SuDS Maintenance Plan 08/09/20 – This is a substitute.

DSM-E4761-014 Rev A “Ditch Maintenance Plan” – This is a new plan

Please find attached the updated SuDS maintenance plan together with a ditch maintenance plan – the engineers responses to the ADC engineers comments are shown in red text below.

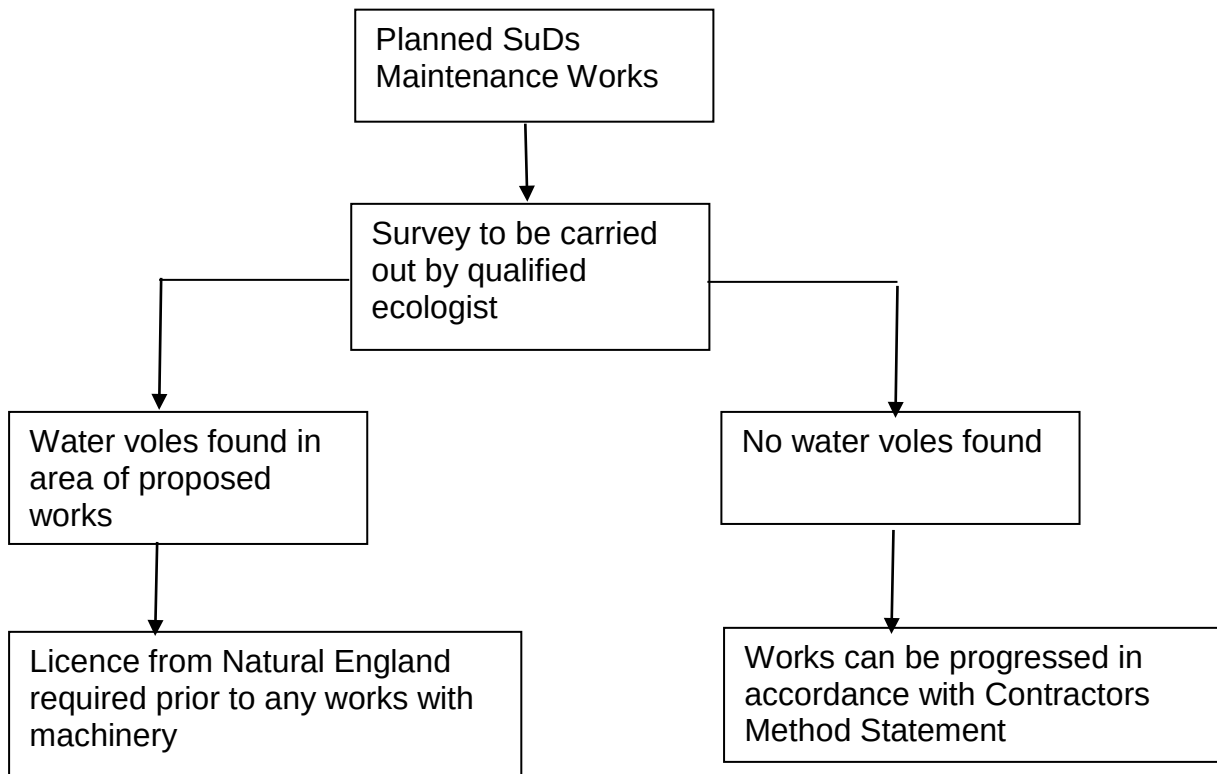
1. There are areas in addition to those currently listed that are the responsibility of the development to maintain. Bridge crossings & Culverts to southern ditch now called up and indicated on Ditch Maintenance Plan.

4. The engineered elements of the ditch should also be included, e.g. replacement of gabions. Gabion replacement/maintenance requirement now added.
5. Details of maintenance of the watercourse to the south, including the bridges should also be included. If this is the responsibility of individual property holders, this must be made clear. This will be the responsibility of the

Management Company and stipulated in the ditches section and on the Ditch Maintenance Plan. This area is also indicated on Conveyance Plan.

6. Details of maintenance to the ditch immediately downstream of the discharge point should be included.” This section has been added to the ditches section in the Maintenance Manual and indicated on the Ditch Maintenance Plan.
